DEPARTMENT OF PUBLIC WORKS

MEMORANDUM

TO: All Staff
FROM: Arden Thomas, Water Resource Manager
DATE: September 3, 2020
SUBJECT: SPF-20-00003 JD's Happy Heights Final Short Plat

SHORT PLAT NOTES:

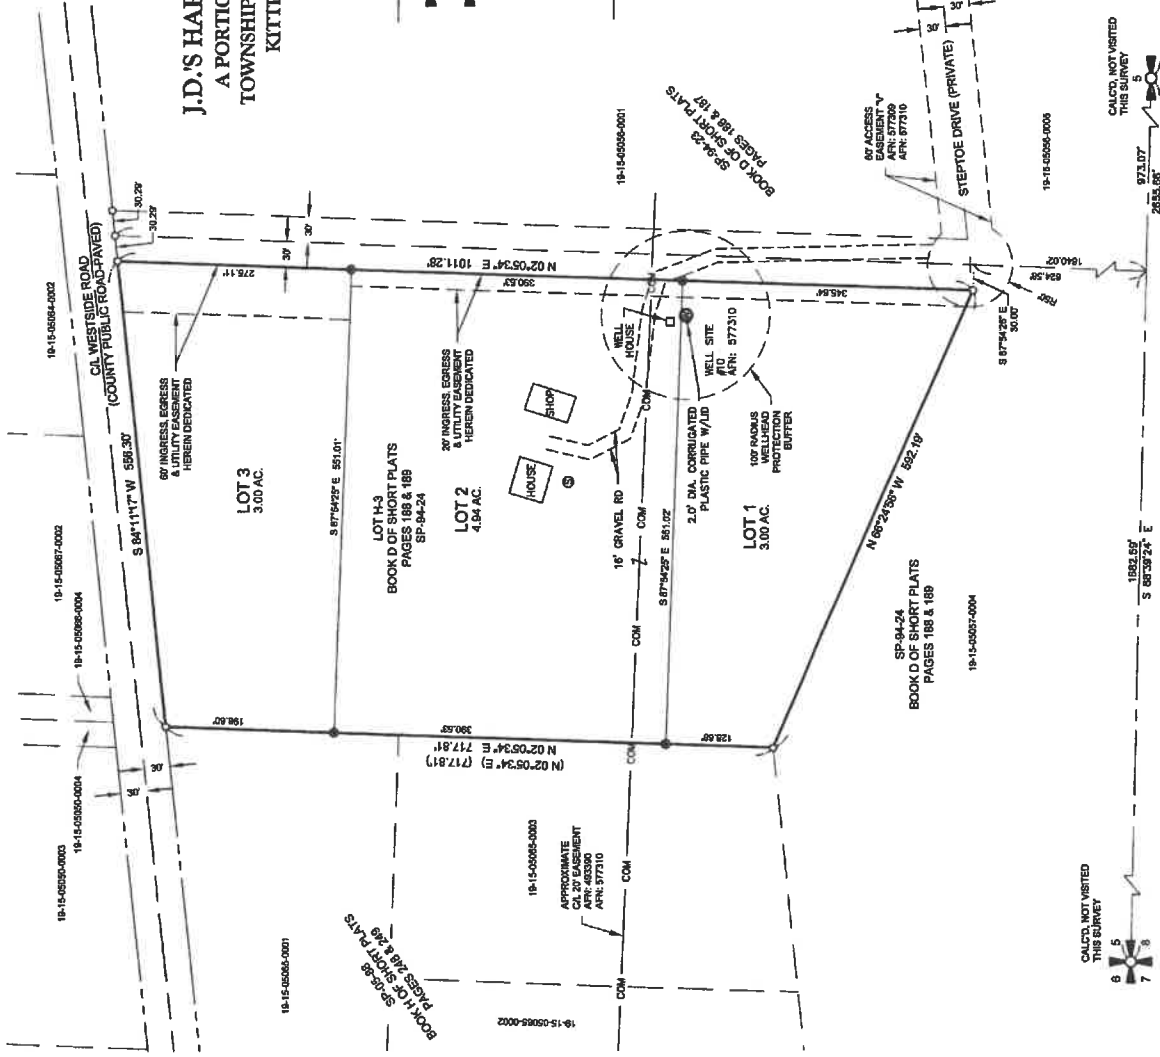
The applicant must provide legal water availability for all new uses on the proposed lots of this project, which can be provided through mitigation certificates (see conditions for final plat approval and recording).

Metering is required for all new uses of domestic water for residential well connections and usage must be recorded in a manner consistent with Kittitas County Code Chapter 13.35.027 and Ecology regulations (see Condition C-1).

The approval of this division of land provides no guarantee that use of water under the ground water exemption (RCW 90.44.050) for this plat or any portion thereof will not be subject to curtailment by the Department of Ecology or a court of law (settlement agreement) (see Condition C-2).

- C-1 "Metering is required for all new uses of domestic water for residential well connections and usage must be recorded in a manner consistent with Kittitas County Code Chapter 13.35.027 and Ecology regulations."
- C-2 "The approval of this division of land provides no guarantee that use of water under the ground water exemption (RCW 90.44.050) for this plat or any portion thereof will not be subject to curtailment by the Department of Ecology or a court of law."
